Application no: **3/2021/1071**

Address: **23 Berry Lane Longridge PR3 3JA**

Proposal: **Proposed change of use of the first floor over the restaurant to a self contained flat.**

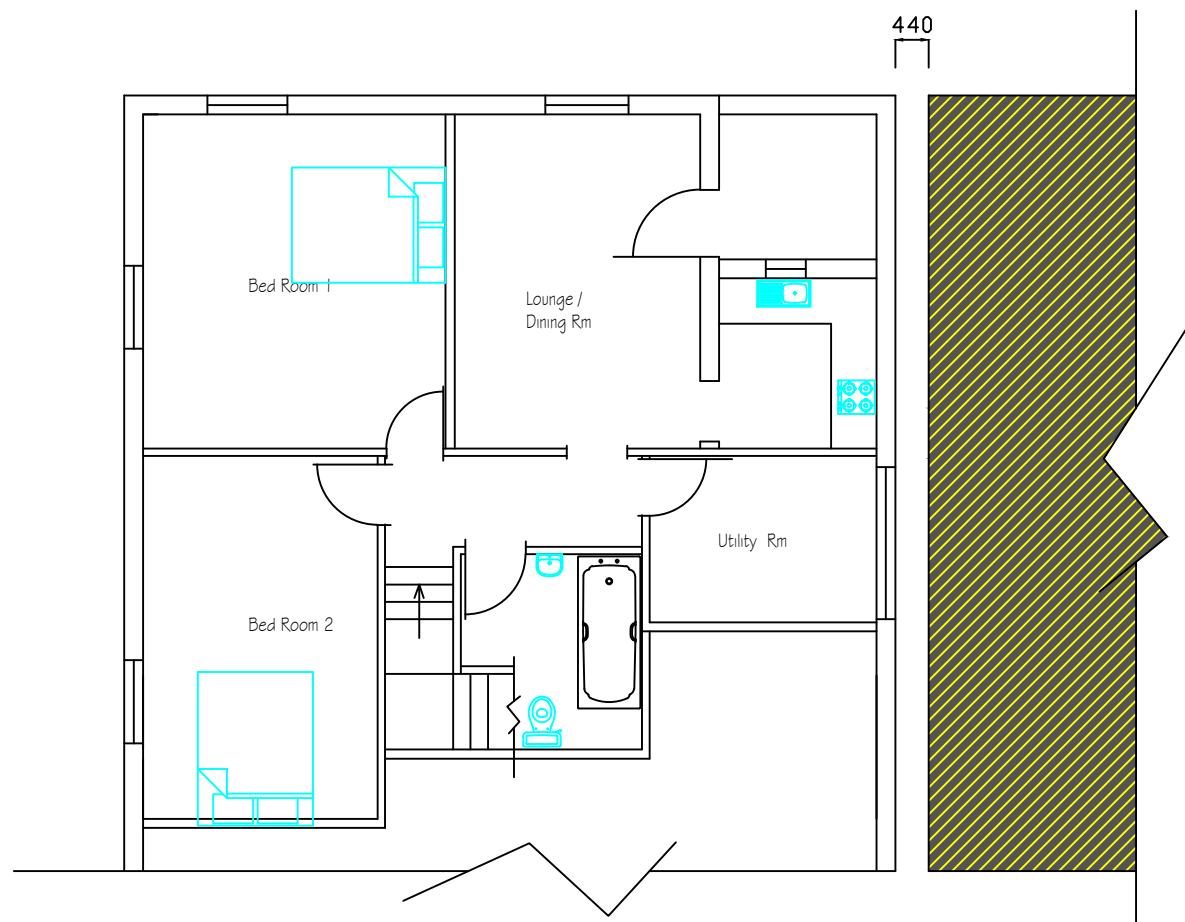
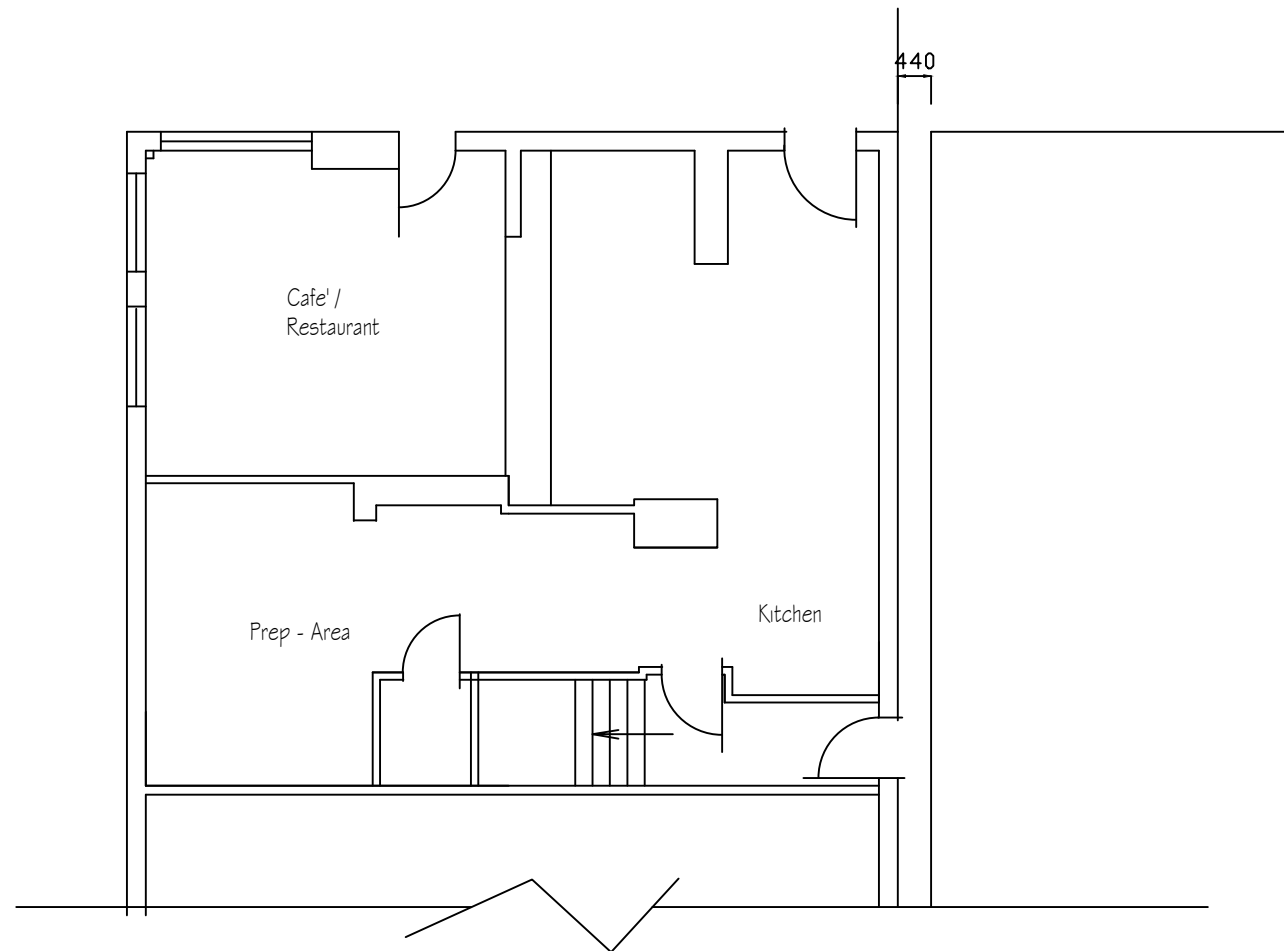
The LHA have reviewed the supporting documents and understands that the proposed flat will become a 2-bed property.

For the site to comply with the LHAs parking guidance as found in the Joint Lancashire Structure Plan, the LHA require 2 car parking spaces to be provided. However, the site are unable to provide any parking spaces and so there is a shortfall in 2 spaces.

Notwithstanding this, the LHA will accept the shortfall in parking at the site. This is because the site is located in the centre of Longridge, where key local amenities are found within walking distance.

1.No building or use hereby permitted shall be occupied or the use commenced until a cycle parking provision plan has been submitted to the Local Planning Authority, in consultation with the Local Highway Authority. The area shall thereafter be kept free of obstruction and available for the parking of cycles only at all times.
